Your Ref: 2020/92800

22nd December 2020

Land at Pennine View/Pheasant Drive, Birstall, Batley – Demolition of existing warehouse and workshop unit and erection of 3 units with reconfigured access, boundary treatment, landscaping and associated works

PROPOSED DRAINAGE LAYOUT.

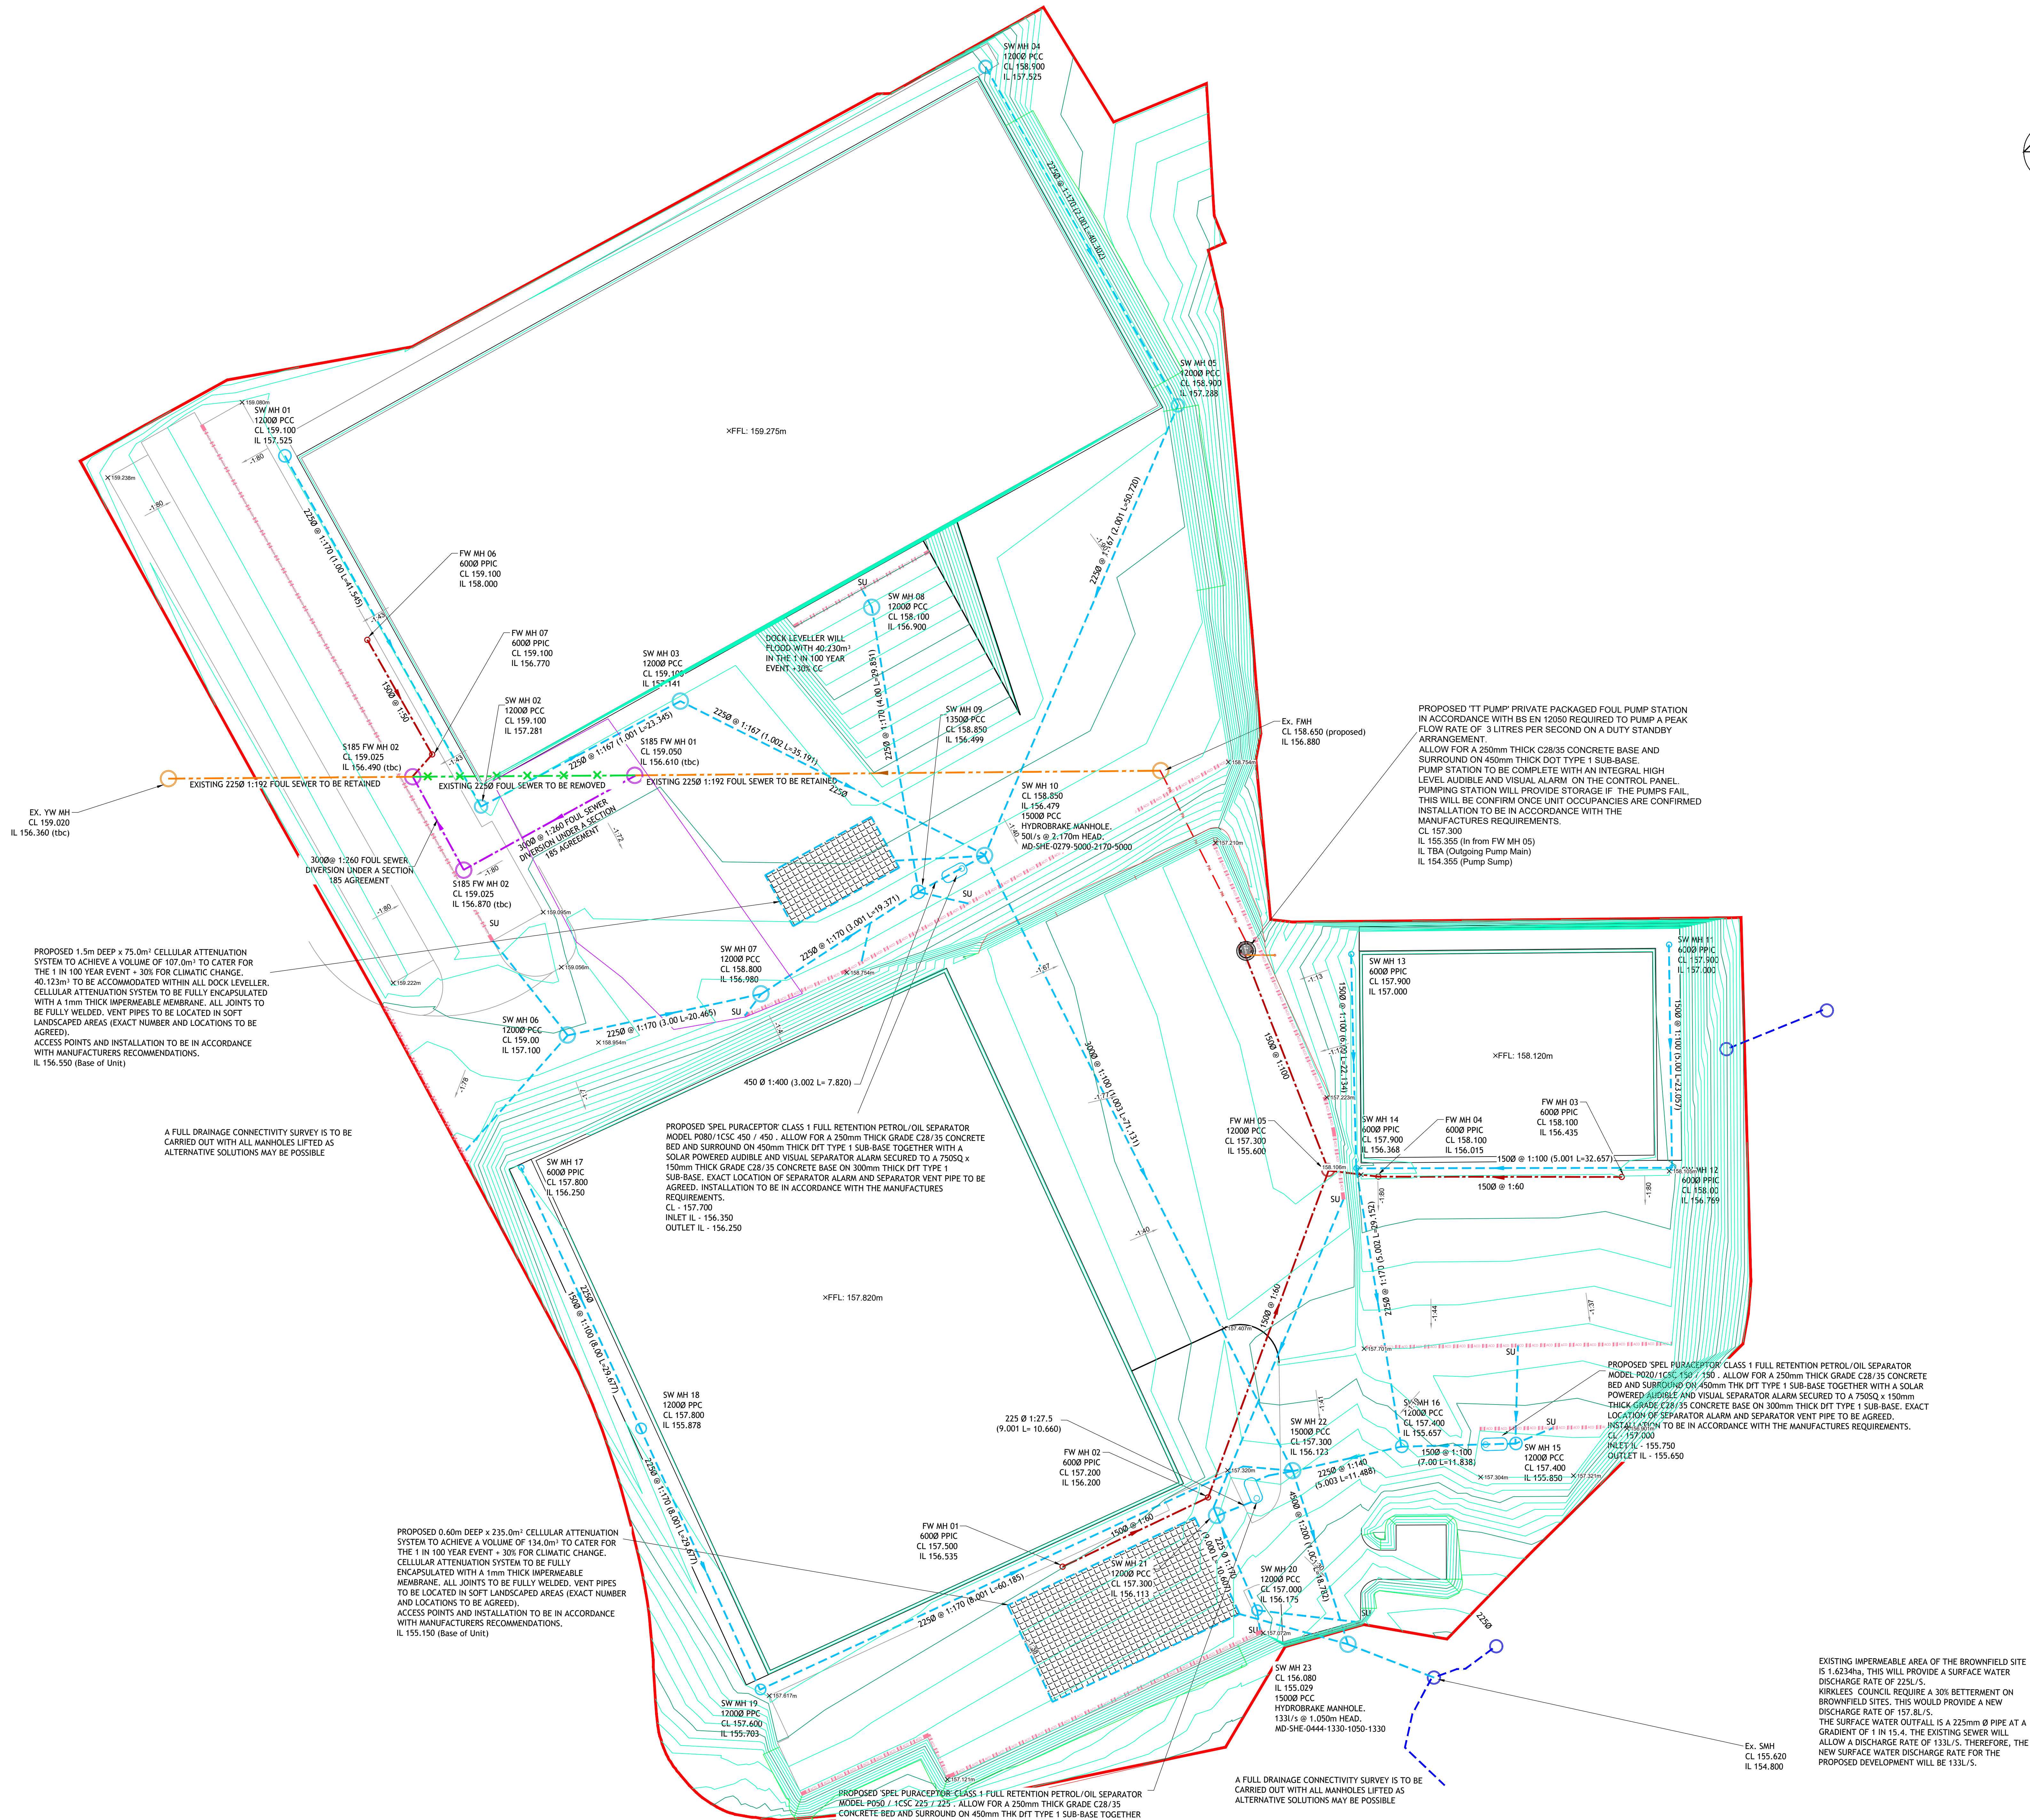
2) The drainage details submitted on drawings 5030 and 5031 (both revision P1) both dated 23/11/2020 that have been prepared by XOsquare require amendments, but if planning permission is granted, the matter can be dealt with via condition. The following points should be addressed:

4) On the Statutory Sewer Map, there is a 225 mm diameter public foul sewer recorded to cross the site. It is essential that the presence of this infrastructure is taken into account in the design of the scheme.

In this instance, a stand-off distance of 3 (three) metres is required at each side of the sewer centre-line and it may not be acceptable to raise or lower ground levels over the sewer, nor to restrict access to the manholes on the sewer. A proposal by the developer to alter/divert a public sewer will be subject to Yorkshire Water's requirements and formal procedure in accordance with Section 185 Water Industry Act 1991.
